From: hda projects [REDACTED]
Sent: 28 October 2019 17:39
To: Nicola Moore
Subject: RE: Preliminary Enquiry Acknowledgement-PE/00786/19 Single storey rear extension: 7 Nursery Cottages, Barnham Lane, Barnham, West Sussex PO22 0JJ
Attachments: 1932 Notification Form Larger Extension 28 10 19.pdf; 1932 P 03 Plans as Proposed 28 10 19.pdf

Single storey rear extension: 7 Nursery Cottages, Barnham Lane, Barnham, West Sussex PO22 0JJ

Plans as Proposed

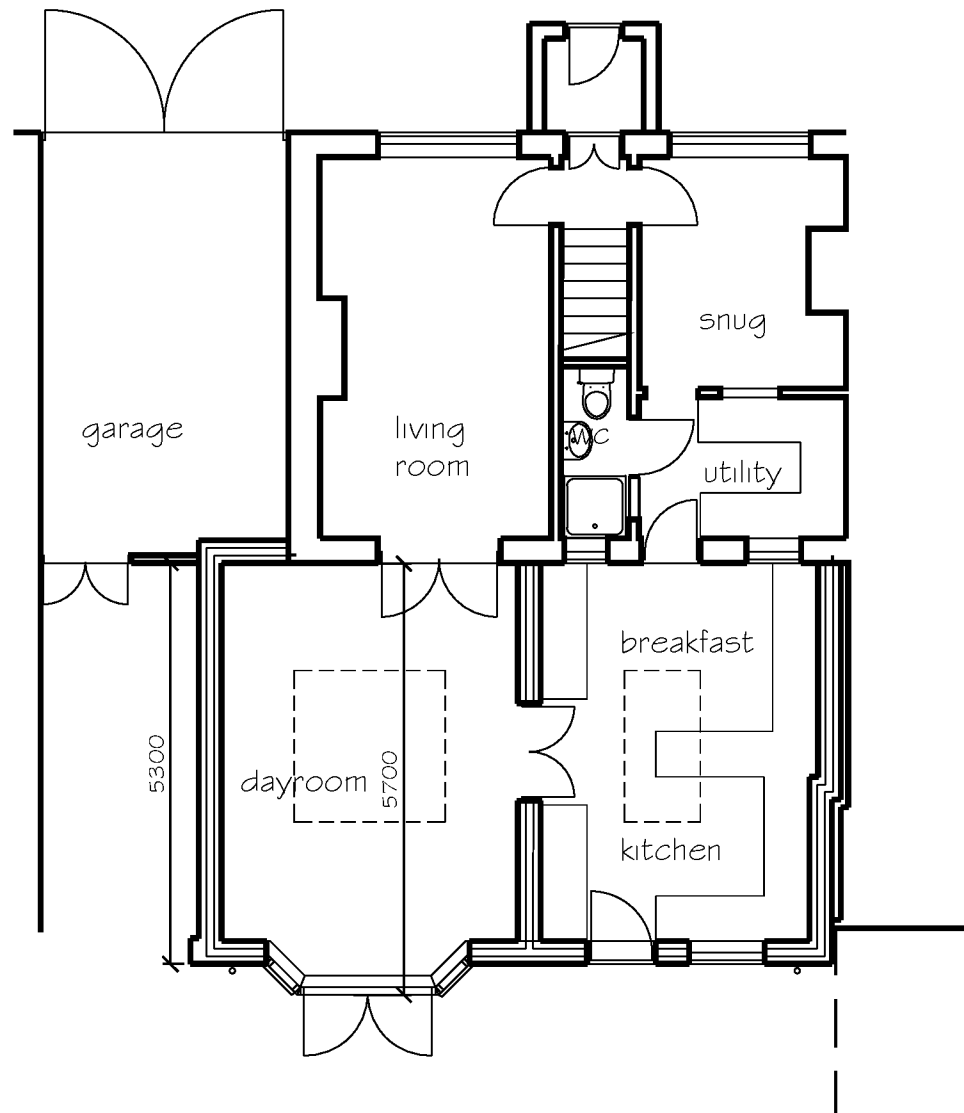
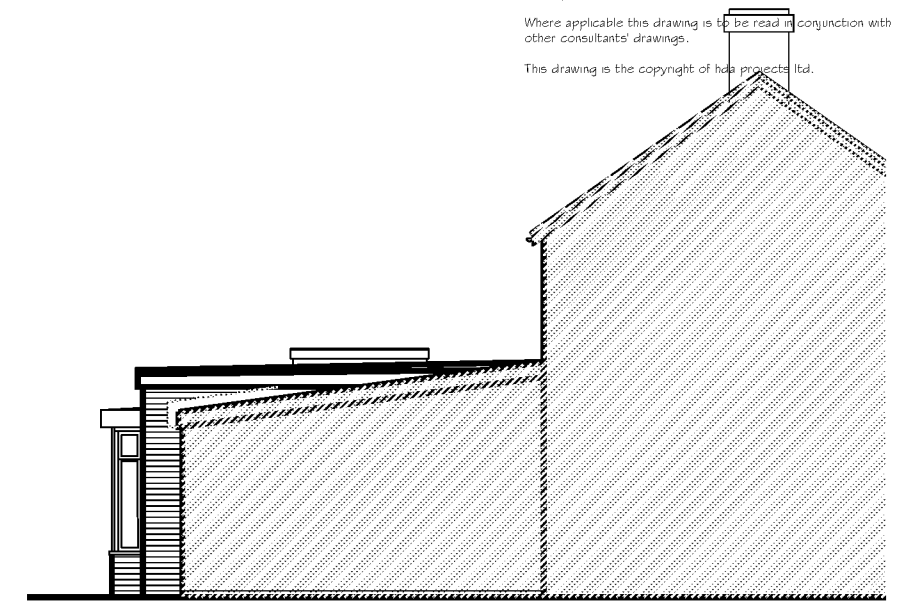
The measurements you have submitted on the application form are:

- How far the proposed extension will extend beyond the rear wall of the dwelling = 5.3m
- The maximum height of the proposed extension, measured externally from the natural ground level = 3.15m
- The height at the eaves of the proposed extension, measured externally from the natural ground level = 3.15m

In order for the application to be processed, please submit a new application form and plans/drawings with amended measurements.

Thank you for your clarification. Amended information attached, the 5.7m includes the bay projection.

Thank you for your response, could we just clarify the point you are raising, the height ground to eaves will be 3.0m within 2.0m of the boundary and the projection 5.7m.
